Our Ref: LU/48/17/L

Application for Listed Building Consent for Alterations, Extension or Demolition of a Listed Building

Development Application for Listed Building Consent for new vehicular access with lych gate and sliding gates
Location Toddington House Toddington Lane Littlehampton

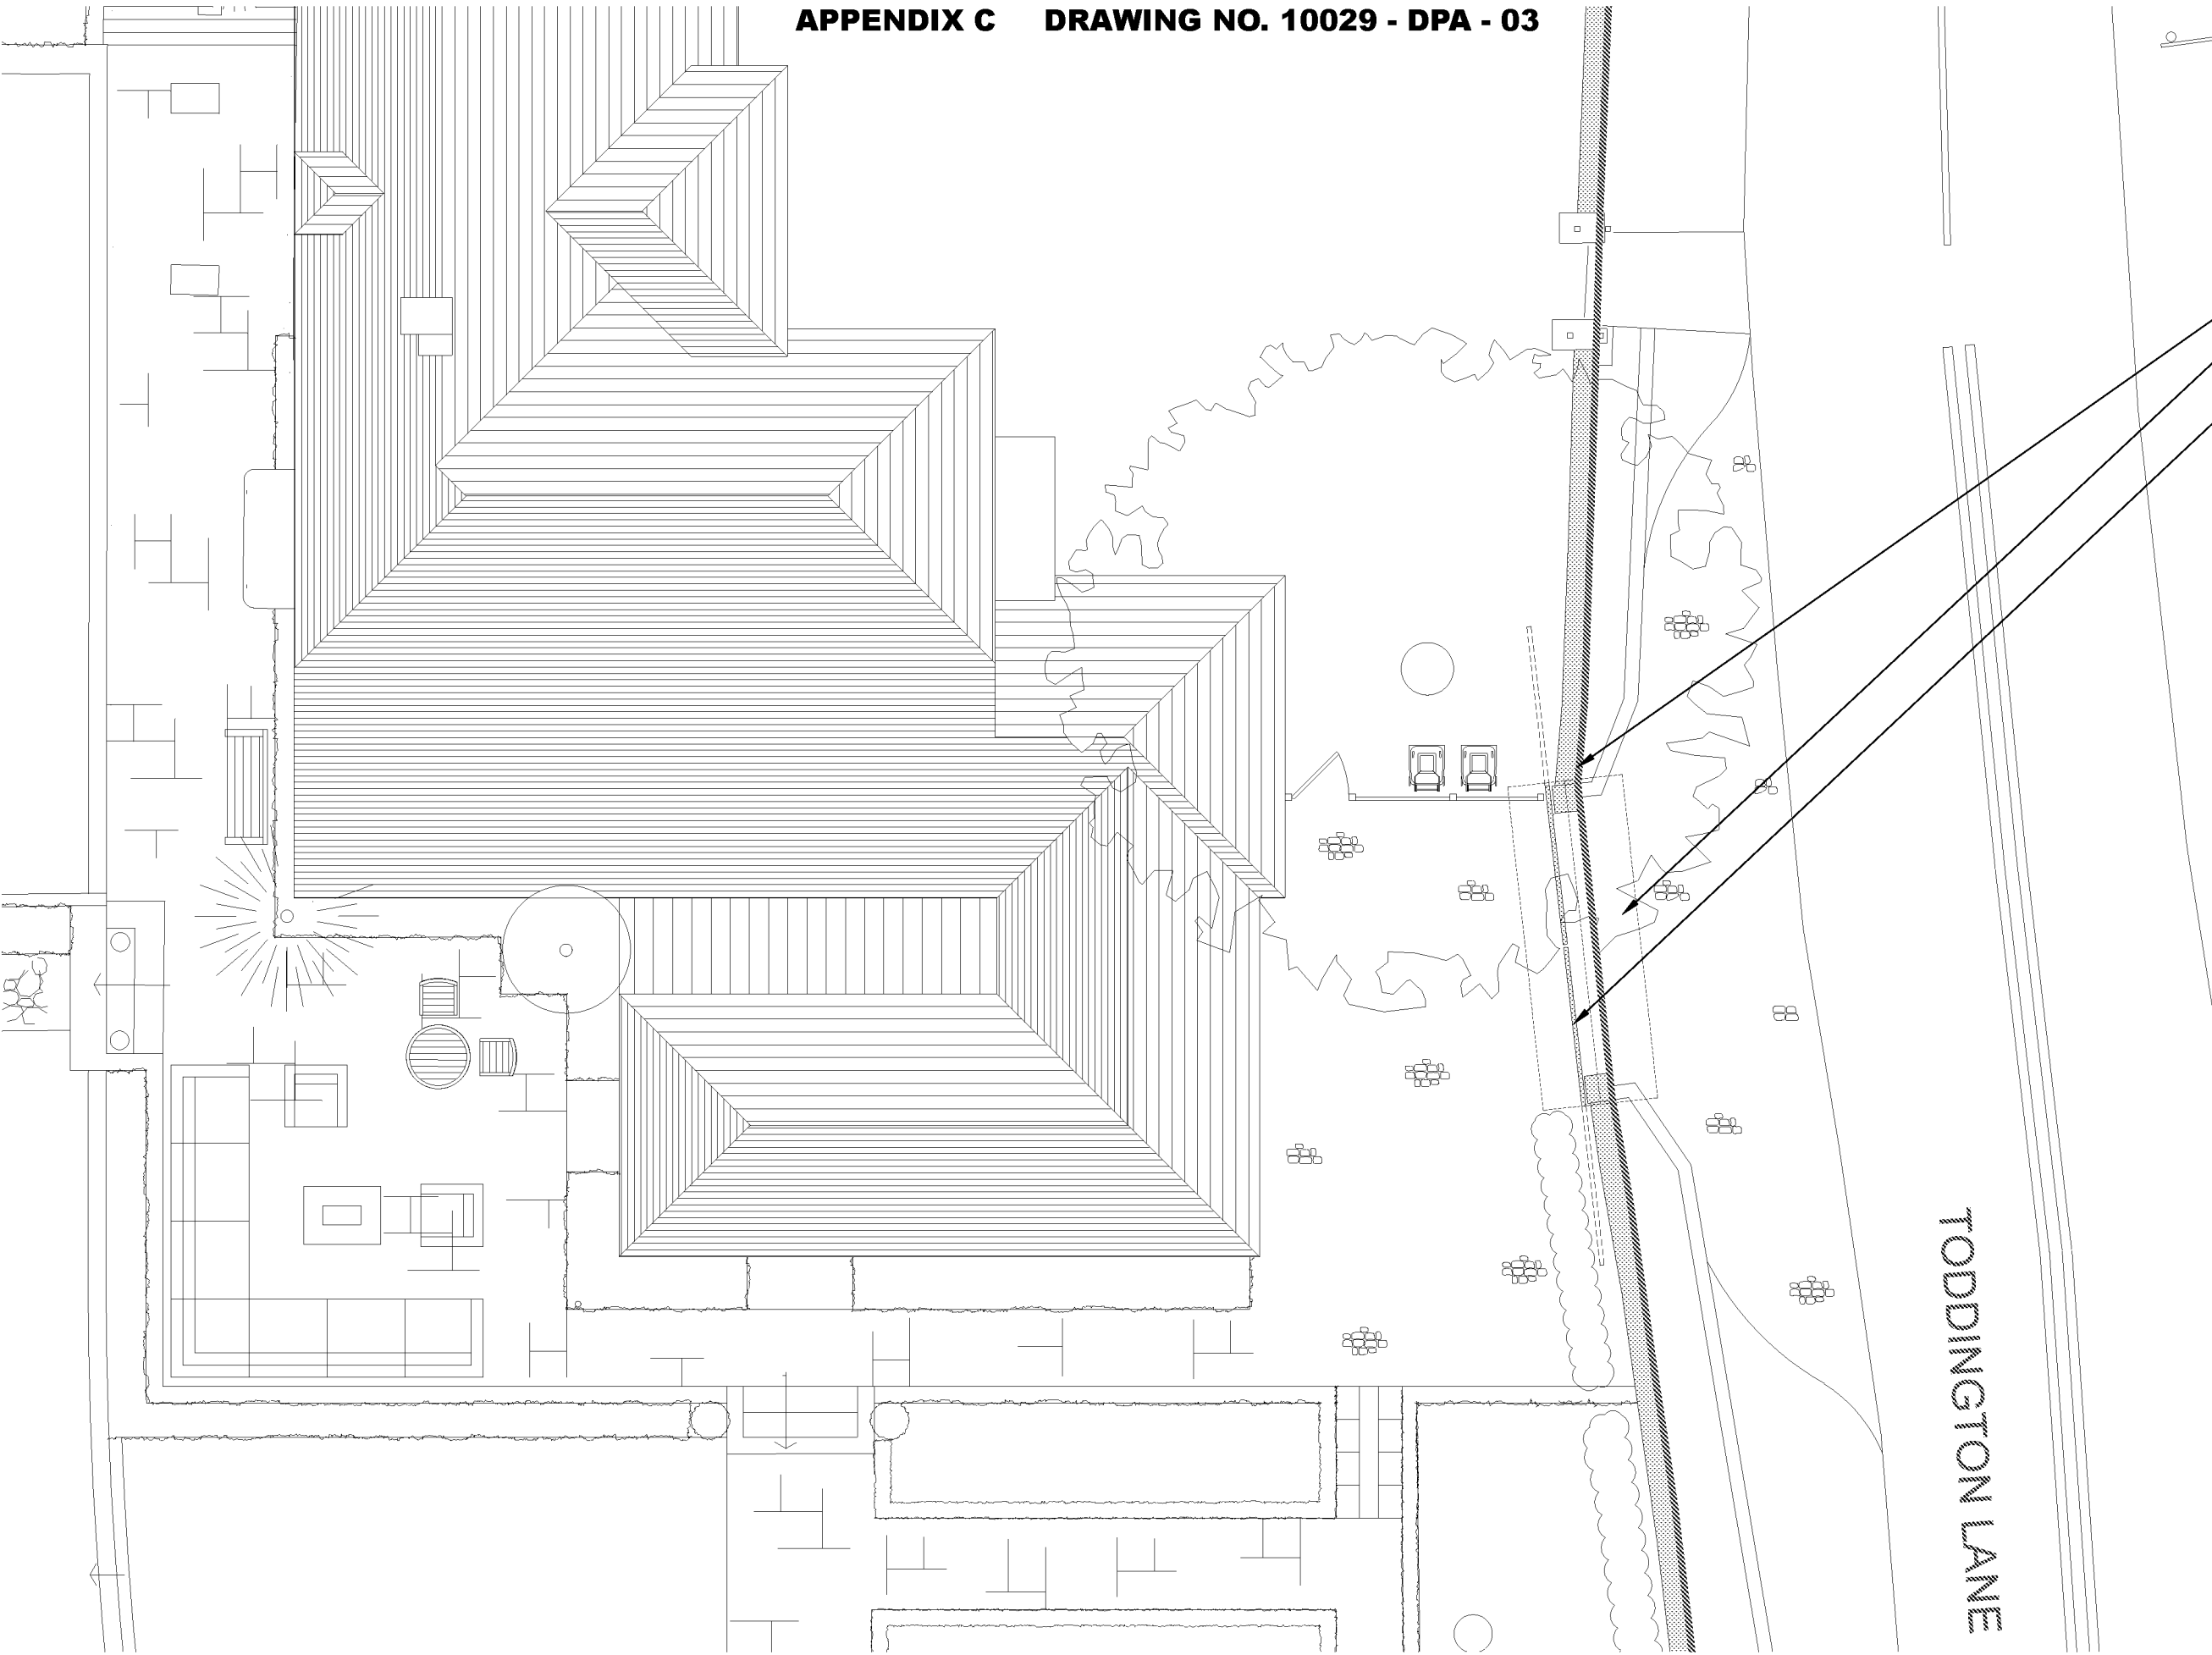
The scale labels on the existing and proposed site plans are incorrect.

As you are applying to change the crossover please confirm whether works will be done to the pavement. If so, this area needs to be within the red outline and the ownership would need to be confirmed. If the applicant does not own this part of the pavement then Certificate B would need to be signed with the road owner (either private or WSCC) would need to be added.
